**Application Reference: 2025/1072**

**Site Address:** Homer House, 335 Burton Road, Monk Bretton, Barnsley, S71 2QF

This application seeks full planning permission for the demolition of garage and erection of a two-storey side extension and inclusion of raised patio area to rear of extension.

Ground Floor Plan 1:50

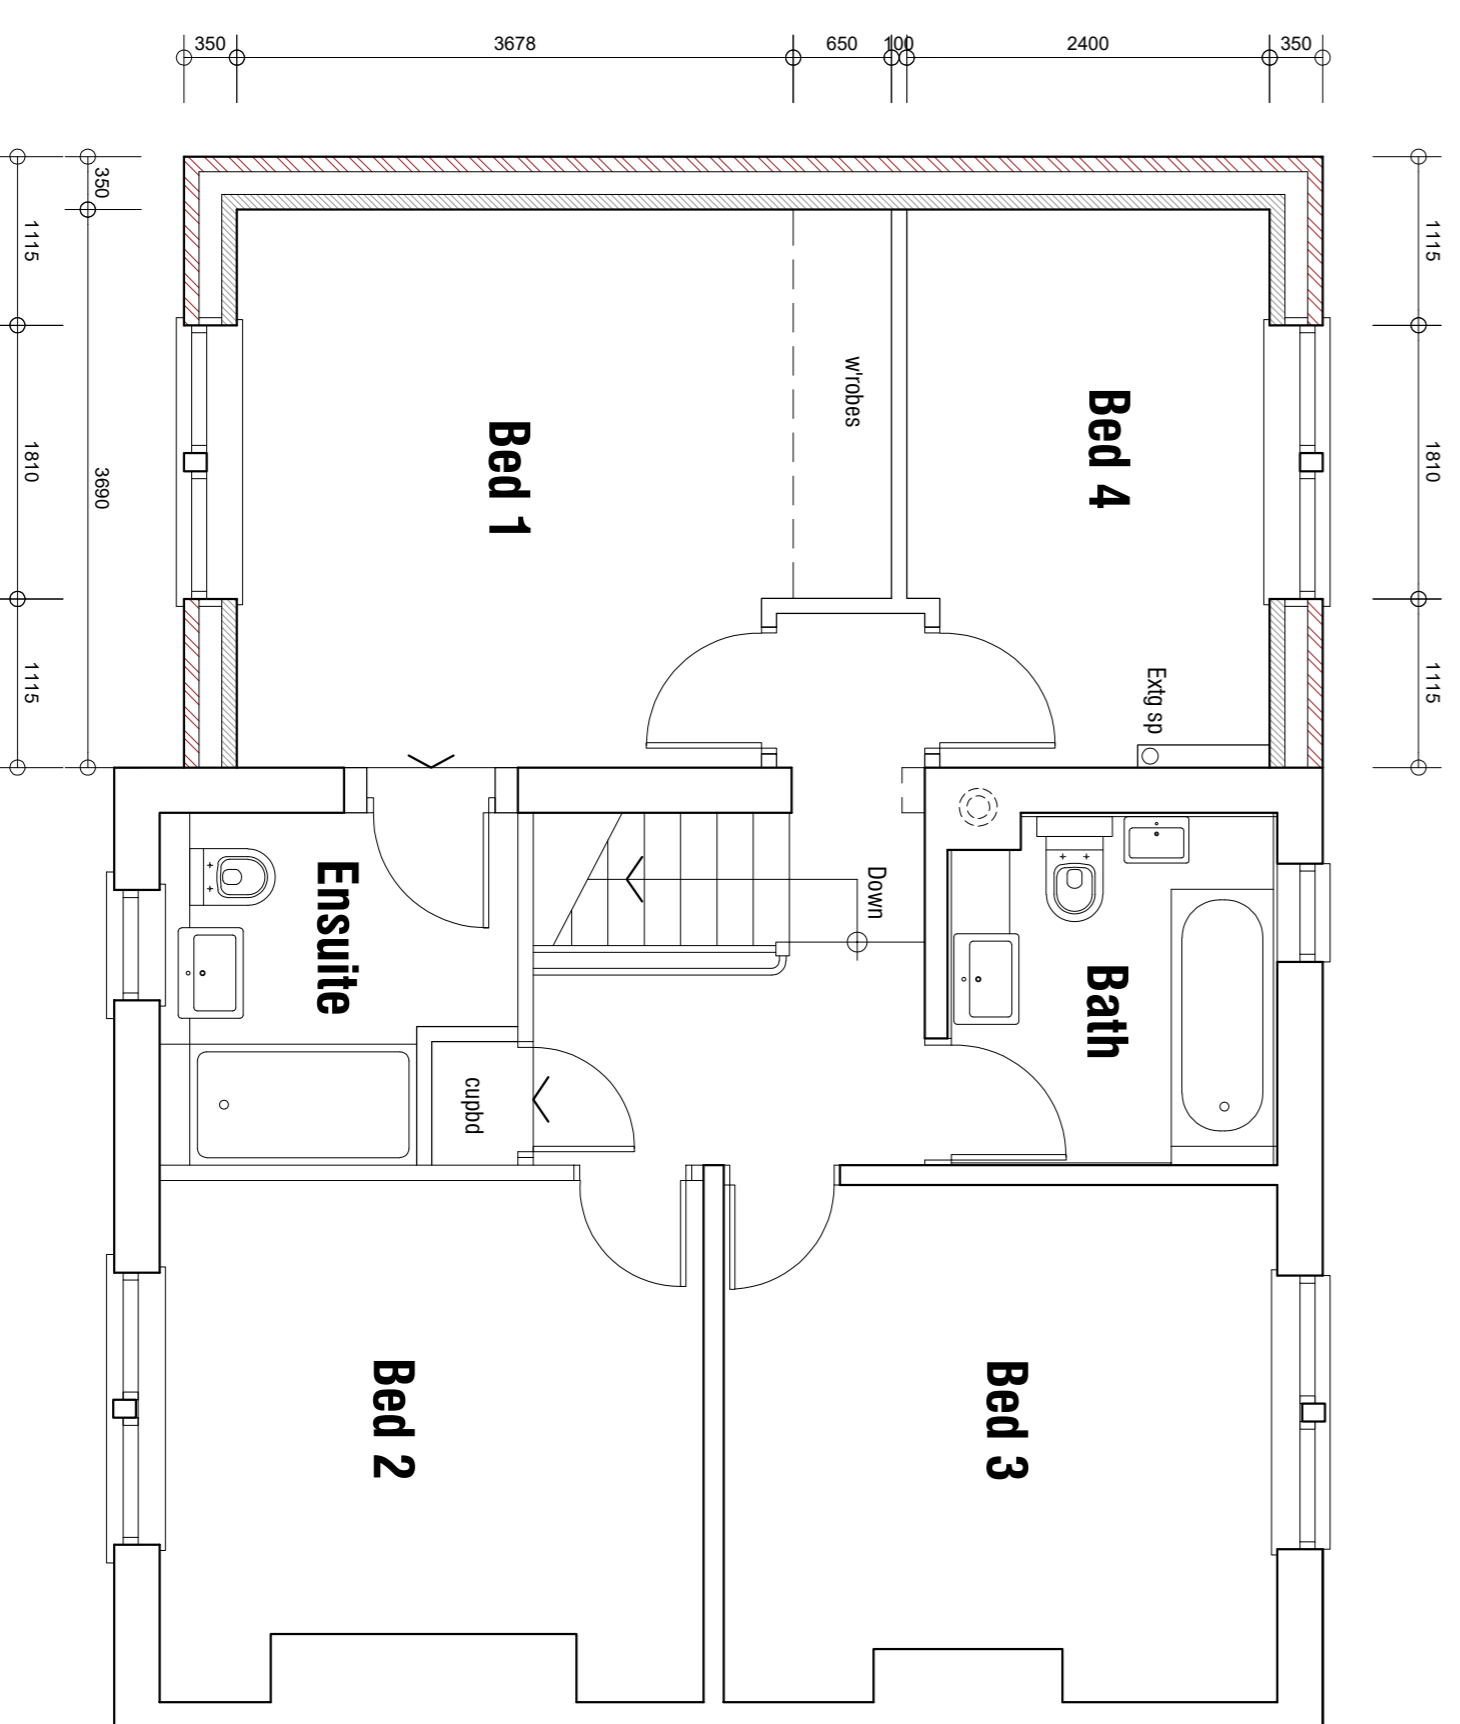
A representation has been received raising concerns about parking. The proposed extension would increase the number of bedrooms from 3 to 4 and as such would not result in a requirement for additional provision. The proposal would however be located on the existing driveway potentially resulting in the loss of off-street parking. The plans submitted indicate that the front garden area is to be hard surfaced in a permeable paving which will provide parking for 2no vehicles. Therefore, there is no loss of off-street parking provision; in addition, there are no on-street parking restrictions to the front of the property. This carries significant weight in favour of the application.

Site Plan 1:200

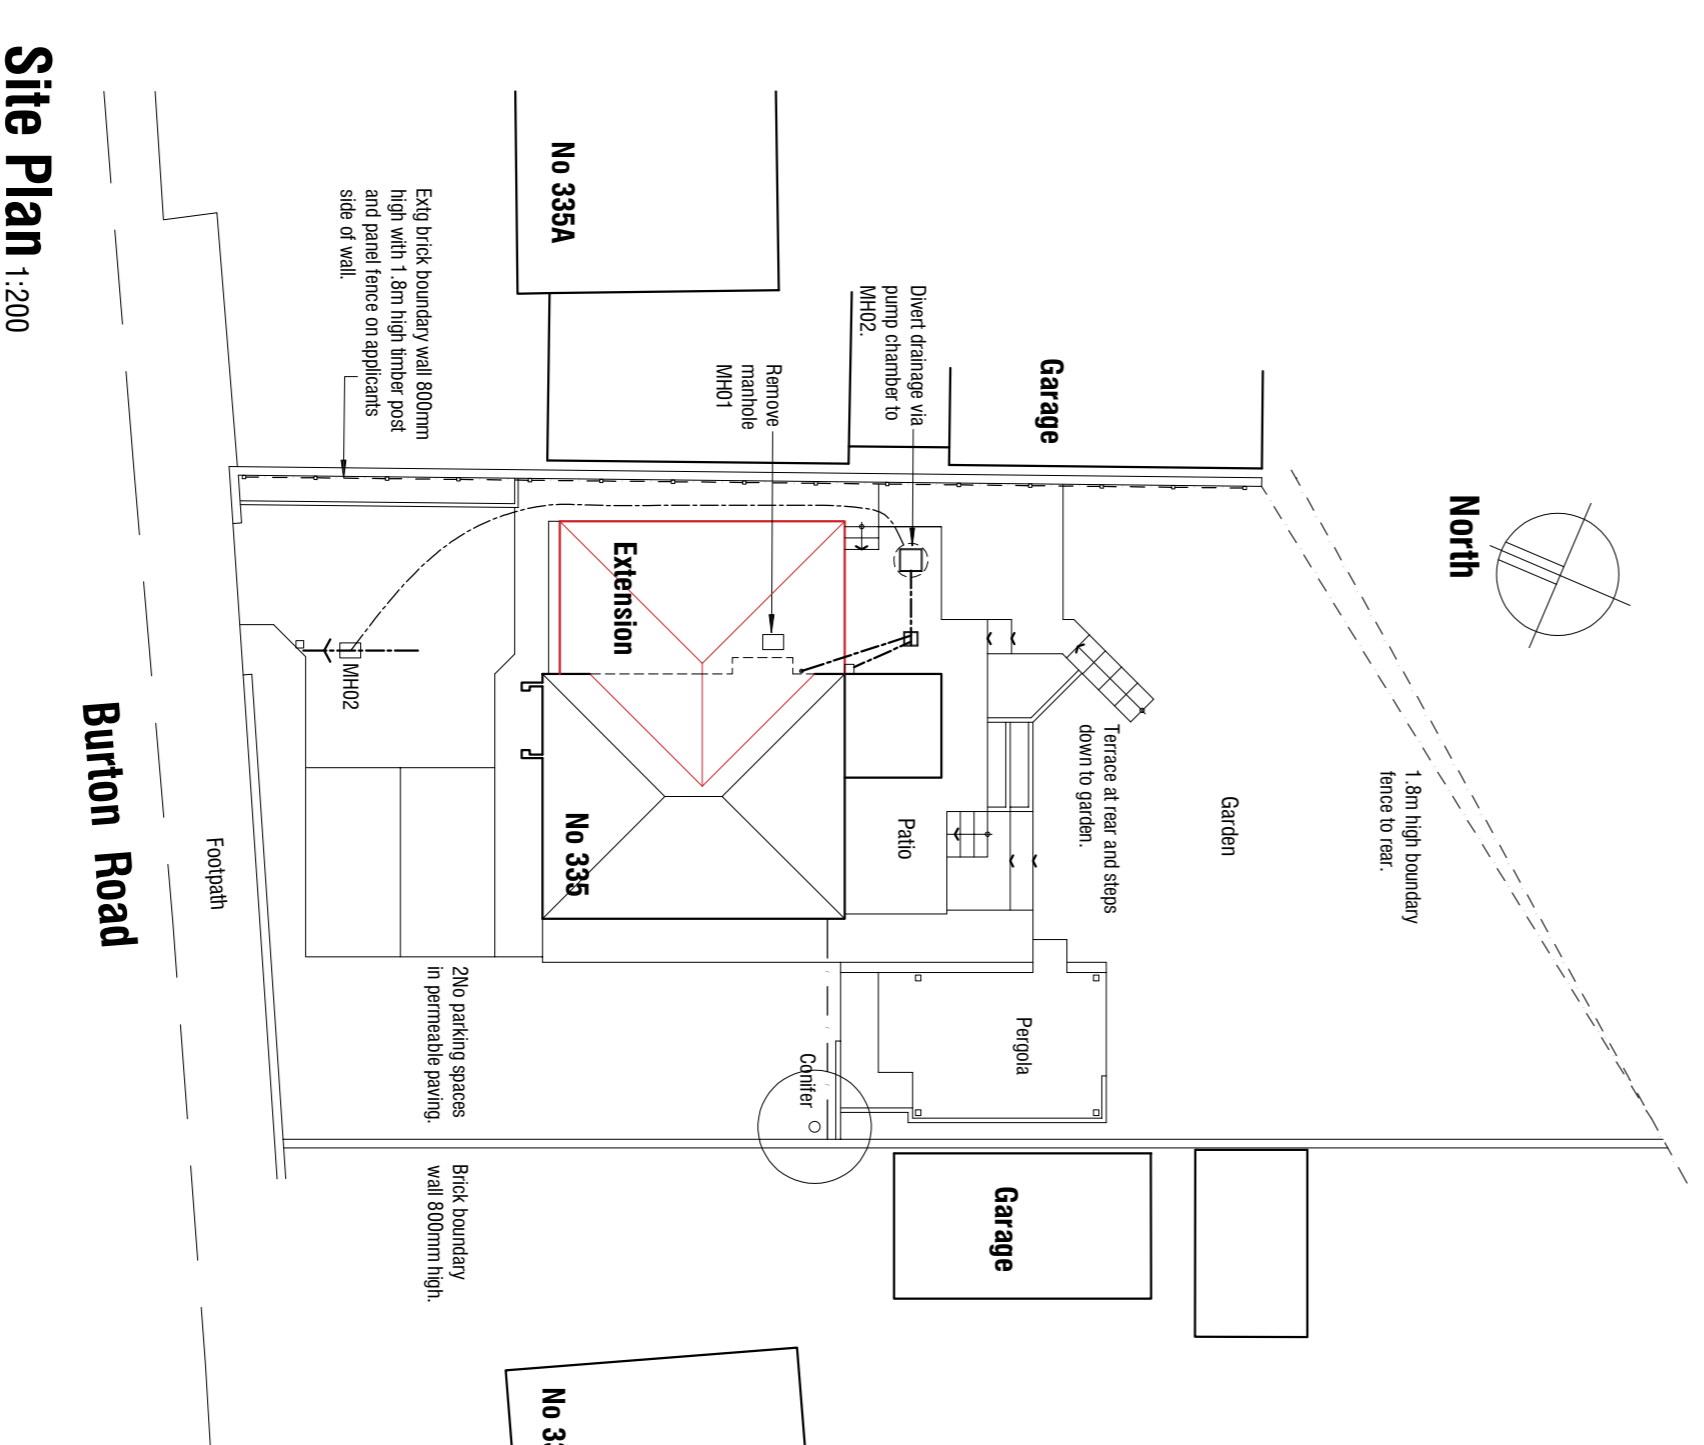
The raised patio area to the rear of the proposed extension creates a level patio along the full width of the property, approximately 0.6m in height and 10m<sup>2</sup>. The area could result in some overlooking of the private amenity space of the neighbouring dwelling, however the area is to be located approximately 1.8m from the boundary, with the existing boundary treatment, and the outbuildings associated with the property providing adequate screening and will limit increased levels of overlooking to a detrimental level.
